**Bramford To Twinstead
Examining Authority Questions to AONB Partnership for DL3 (31 Oct 2023)**

ELEVATION - A
 SCALE 1:150

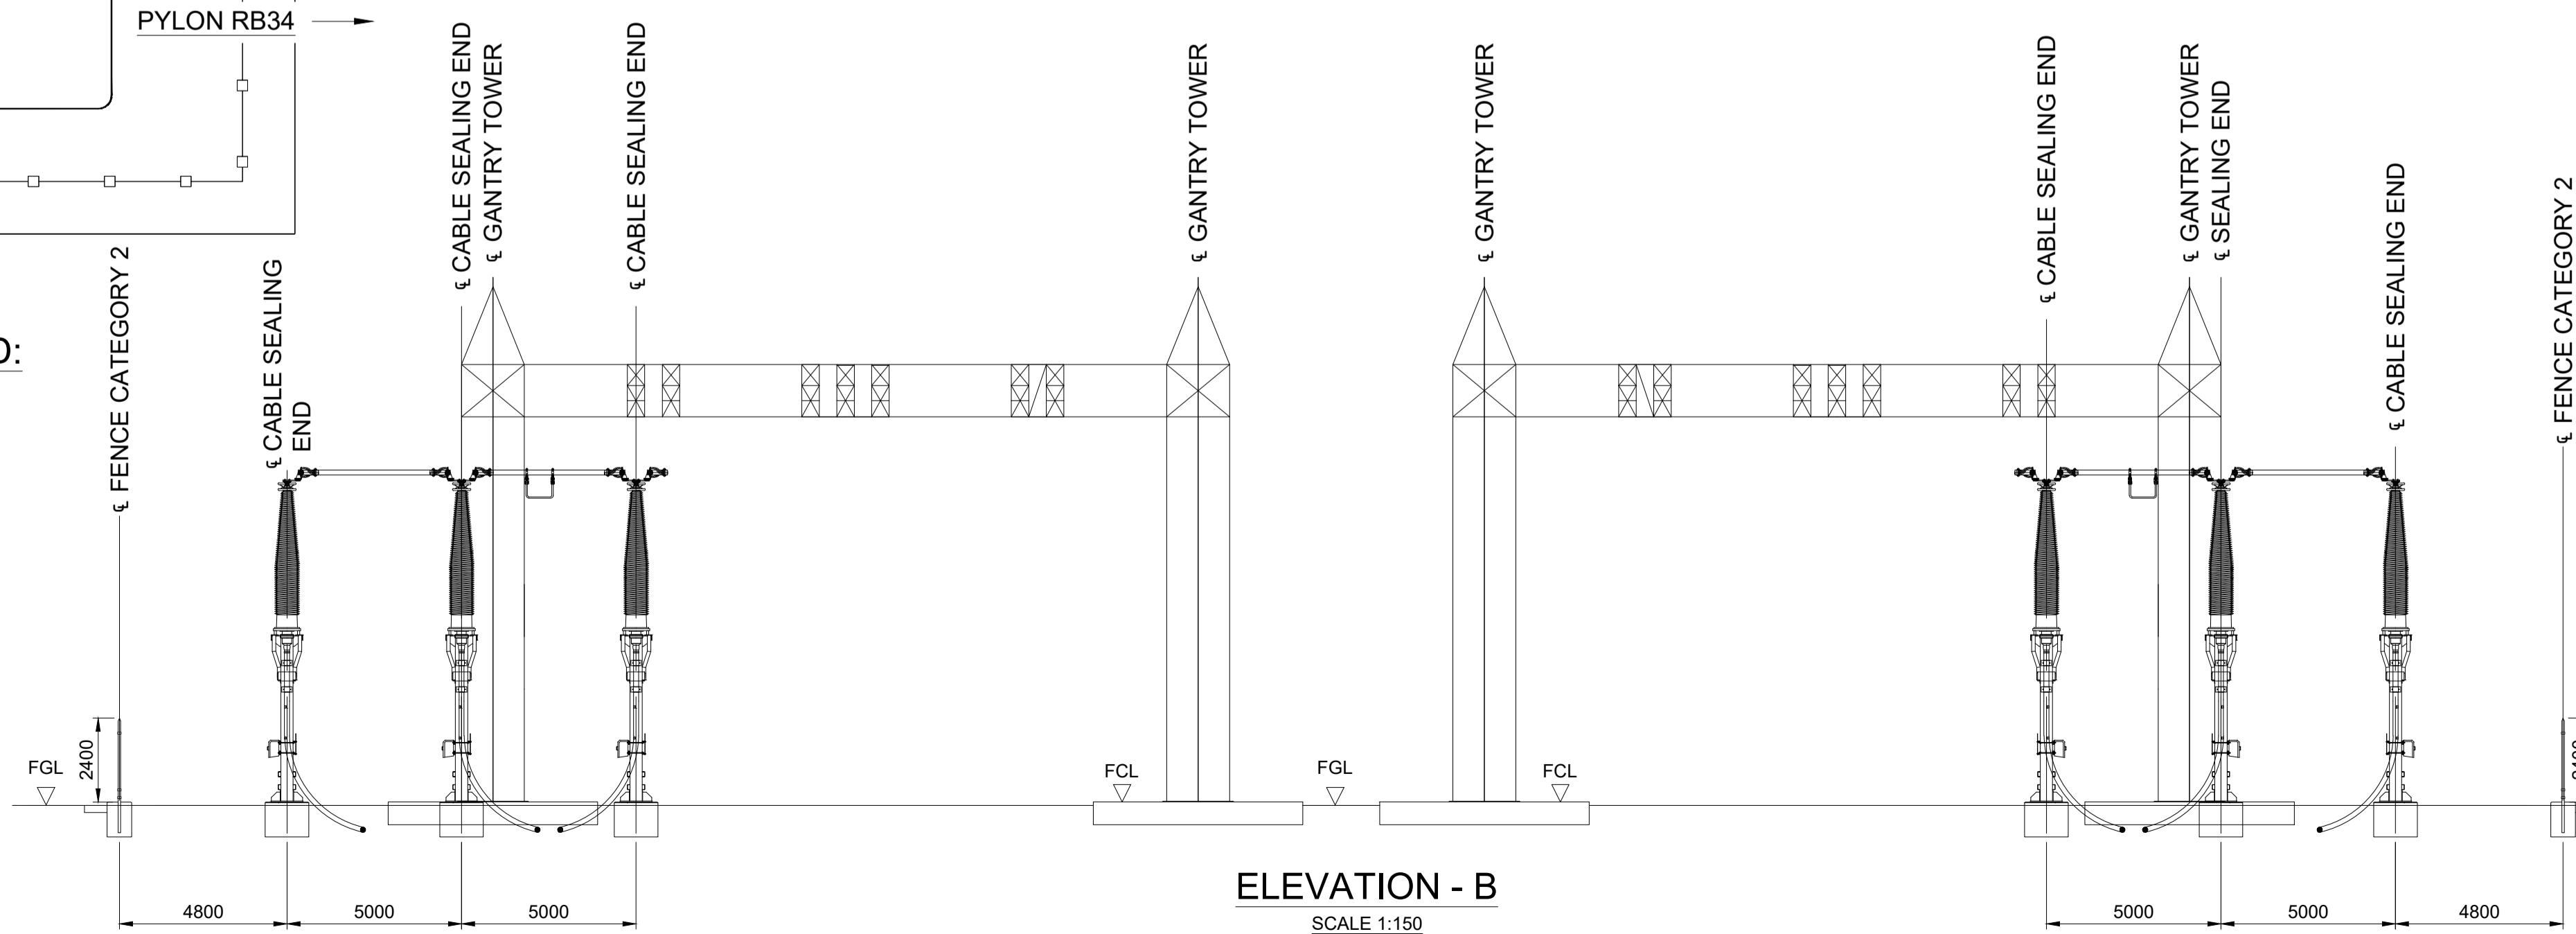
<p>[REP1-025] Section 2.13: The Dedham Vale AONB and Stour Valley Partnership considers that the proposed revised location of the Dedham Vale East Cable Sealing End Compound will not cause significant harm to the AONB but that local receptors should be considered.</p> <p>[REP1-025] Section 3.9: The Dedham Vale AONB and Stour Valley Partnership consider that the applicant is underplaying the assessed impacts on the AONB in the statement from this document:</p> <p><i>The natural beauty indicators of the AONB - notably scenic quality, relative wildness and relative tranquillity would be adversely affected. Given however that these significant adverse effects would be experienced relatively locally within approximately 1km of the LoD and would be short term, temporary and mainly reversible, it is not considered that the overall integrity of the AONB would be affected.</i></p> <p>It considers that the nationally designated landscape is a single entity and as such impact to part of the AONB is an impact to the entity of the AONB.</p> <p>The Dedham Vale AONB and Stour Valley Partnership broadly welcome the undergrounding of cables through the nationally designated landscape, noting the care required to minimise negative impacts on important habitats and archaeological assets. It notes that the driver for undergrounding is national policy (para 2.9.20 National Policy Statement for Electricity Networks Infrastructure (EN-5)) and it should not be seen as compensation for the negative impacts of the scheme during construction, particularly on the natural beauty indicators of scenic quality, relative wildness and relative tranquillity.</p>
